# **Annex 1 to Submission by North Somerset Council in respect of Action point 19 ISH 5 -Environmental matters**

## **March 2021**

Following receipt of the cross-sectional details of the proposed Trinity footbridge North Somerset Council as Local Planning Authority considers that in relation to the impacts of overbearing impact and adverse visual impact these may be slightly less severe than we had feared previously

Figure 14: 21st December 10am

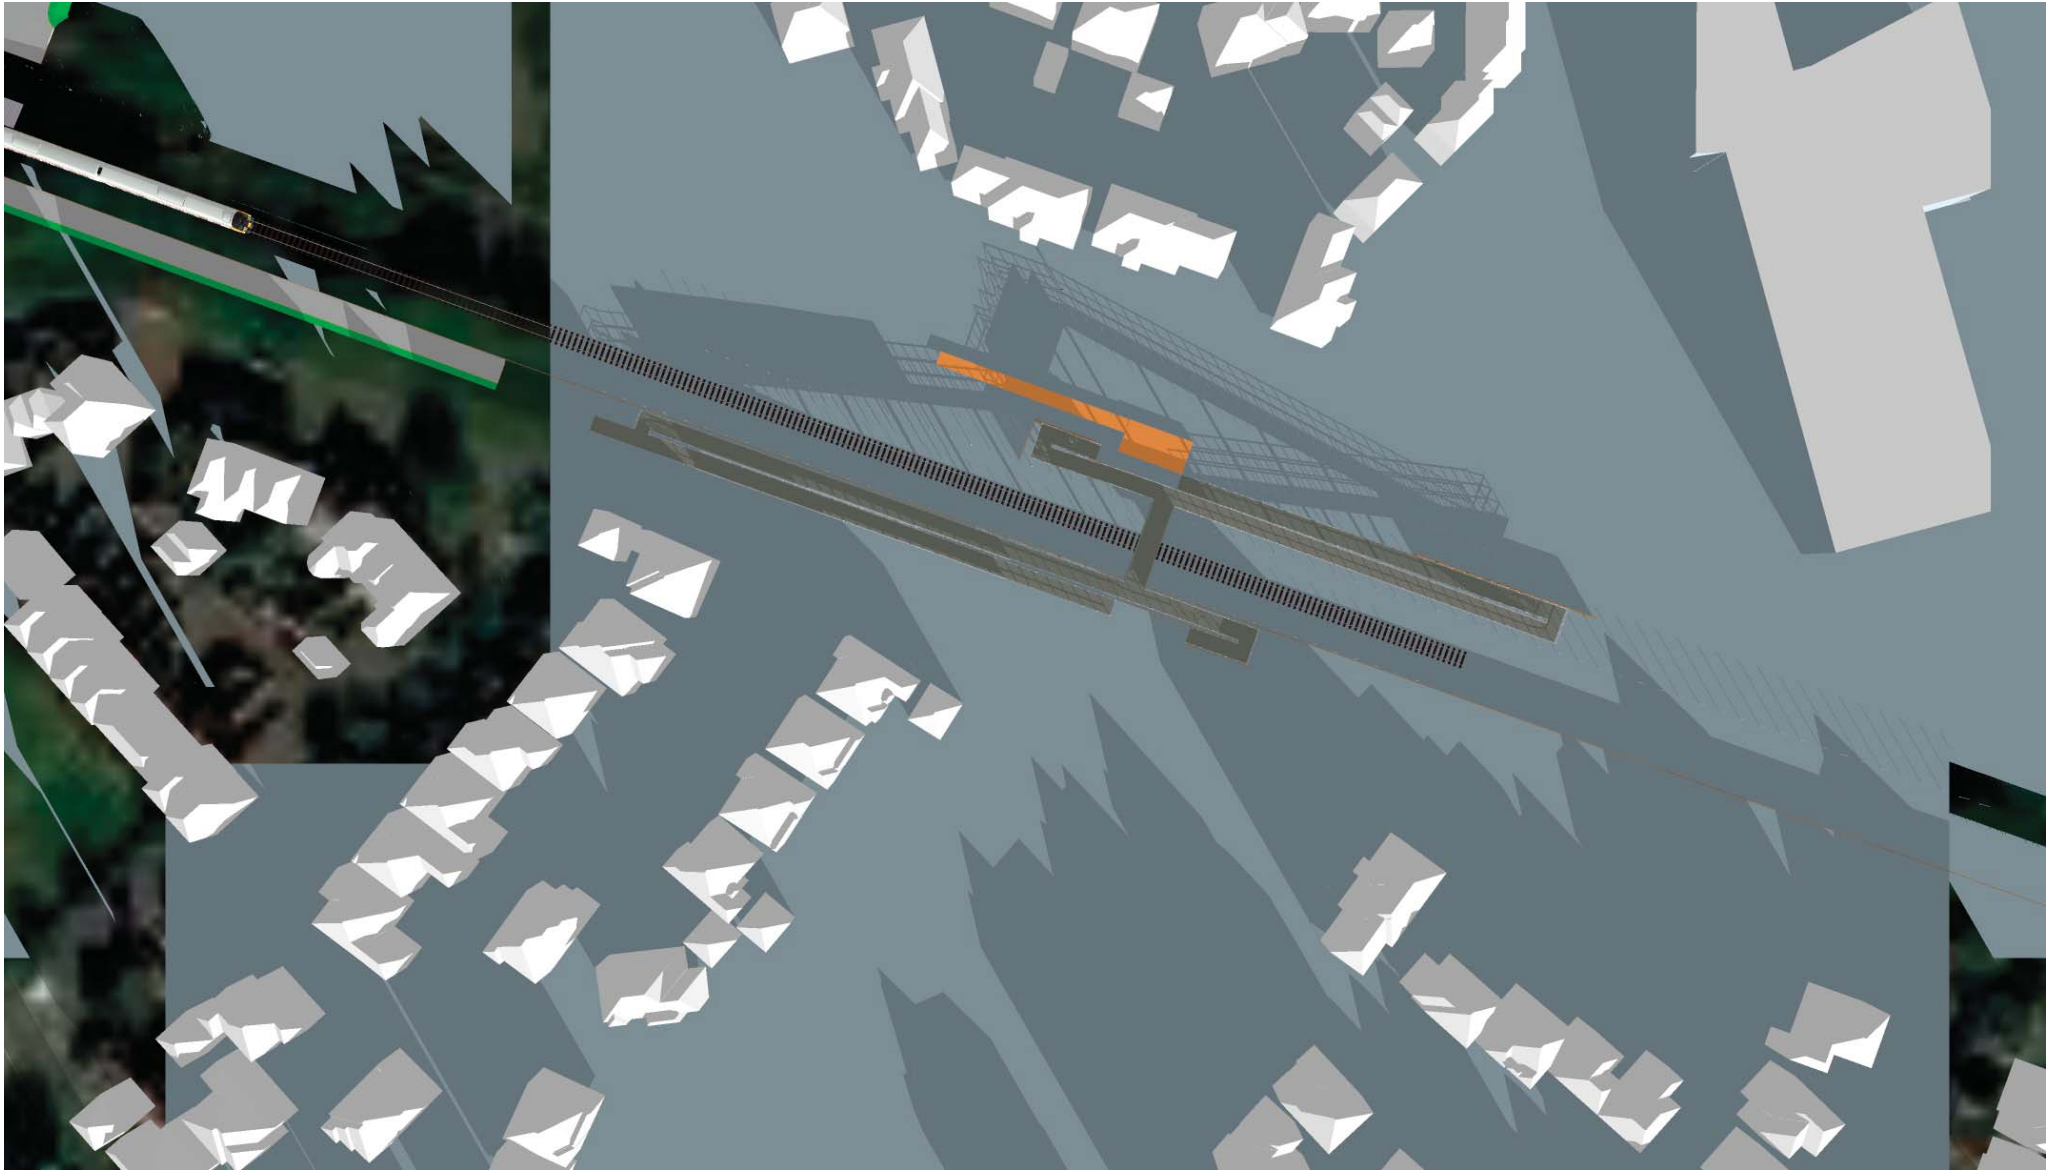
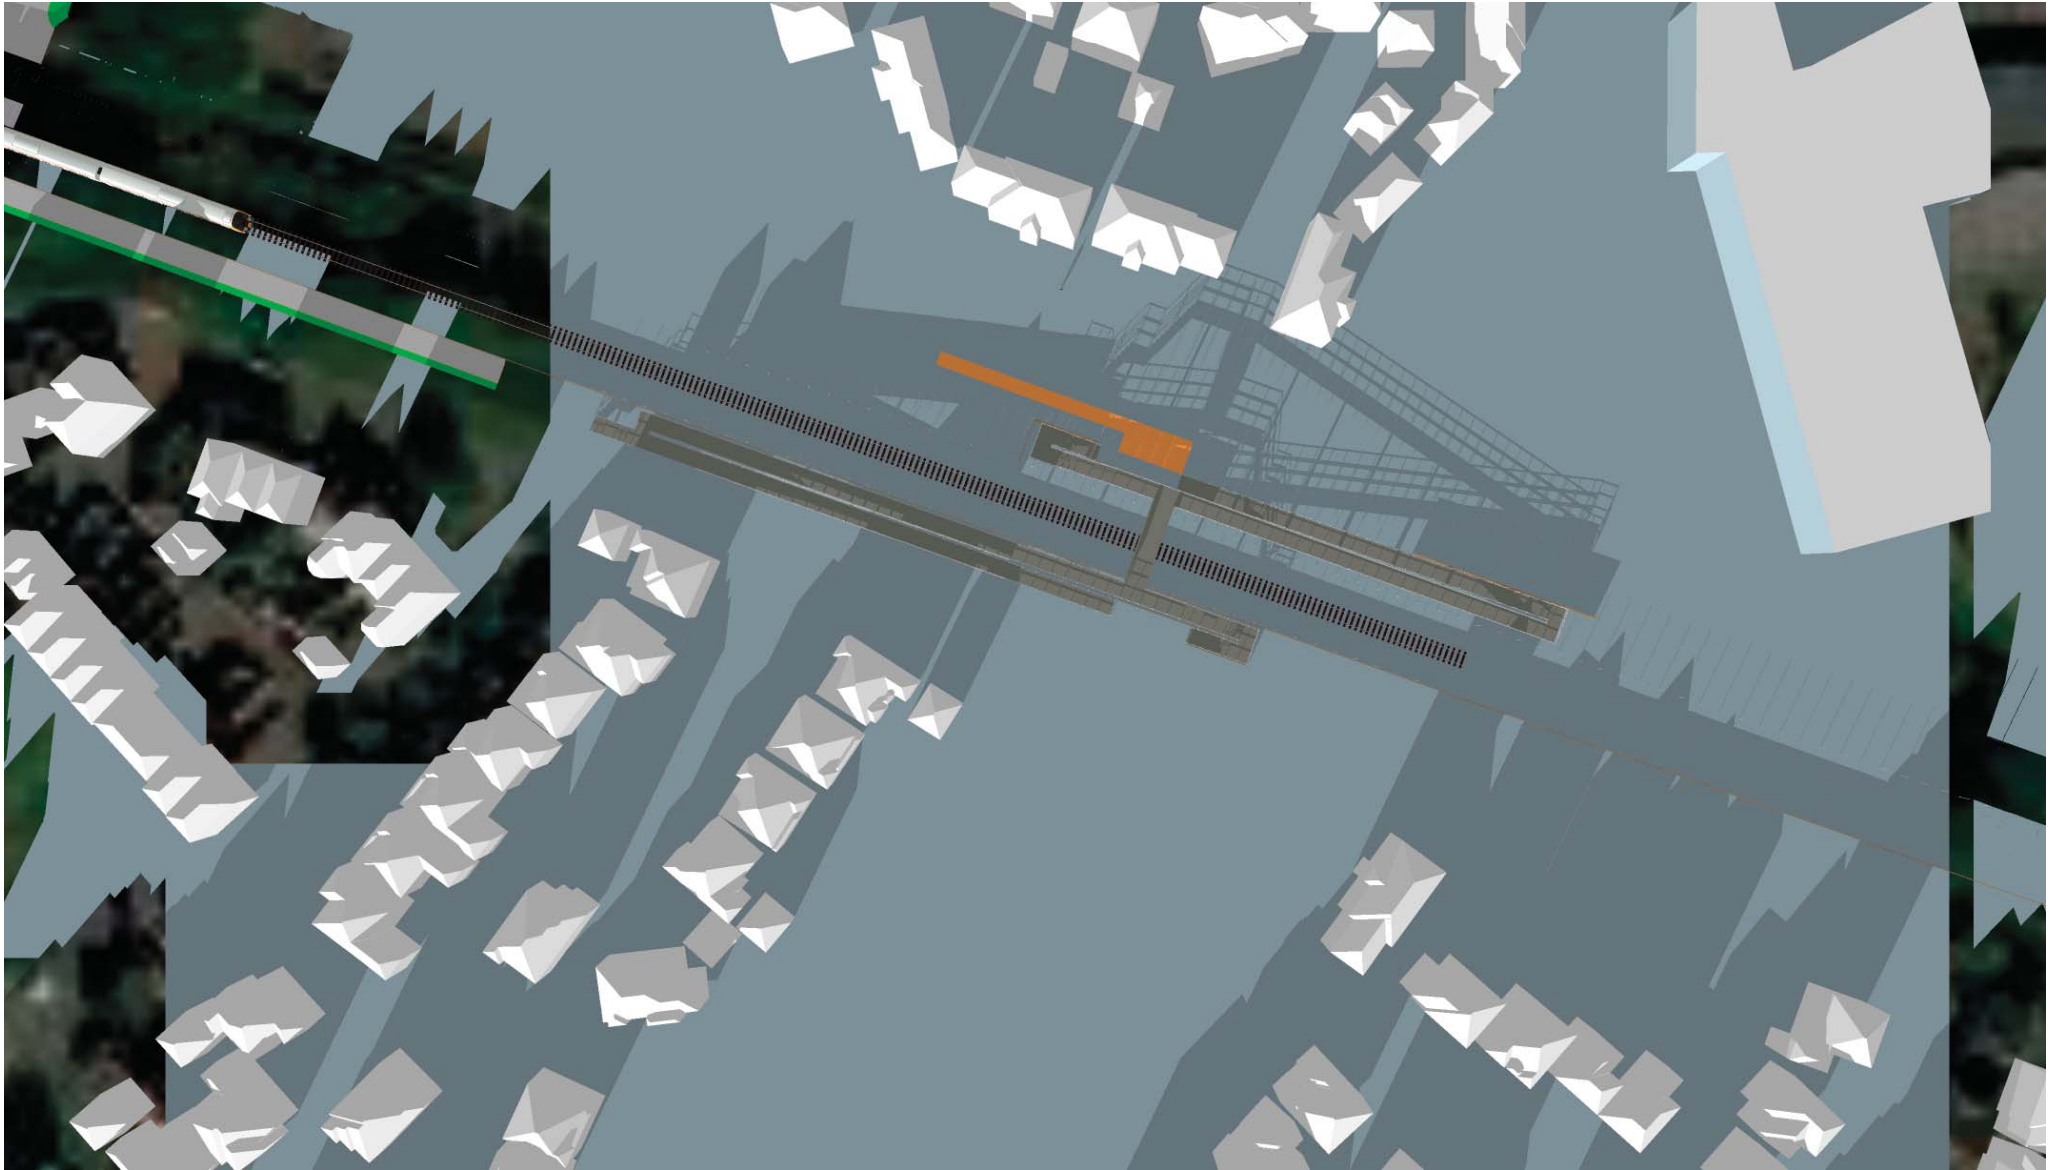
Following receipt of the shadow diagrams it is now easier to assess the impacts that these structures will have on surrounding properties.

The study presents shade impact graphics at 10:00am, 12:00am, 2:00pm and 4:00pm during Spring Equinox, Summer Solstice, Autumn Equinox and Winter Solstice. We consider that this provides sufficient information. From this information, it appears that the footbridge structures have the *potential* to overshadow properties along Tansy Lane (No 9, 11, 15 in particular) rather than properties to the south of the bridge.

From these graphics, it appears that these structures would have no impact at most times and periods of the year on these properties, except for the Winter Solstice
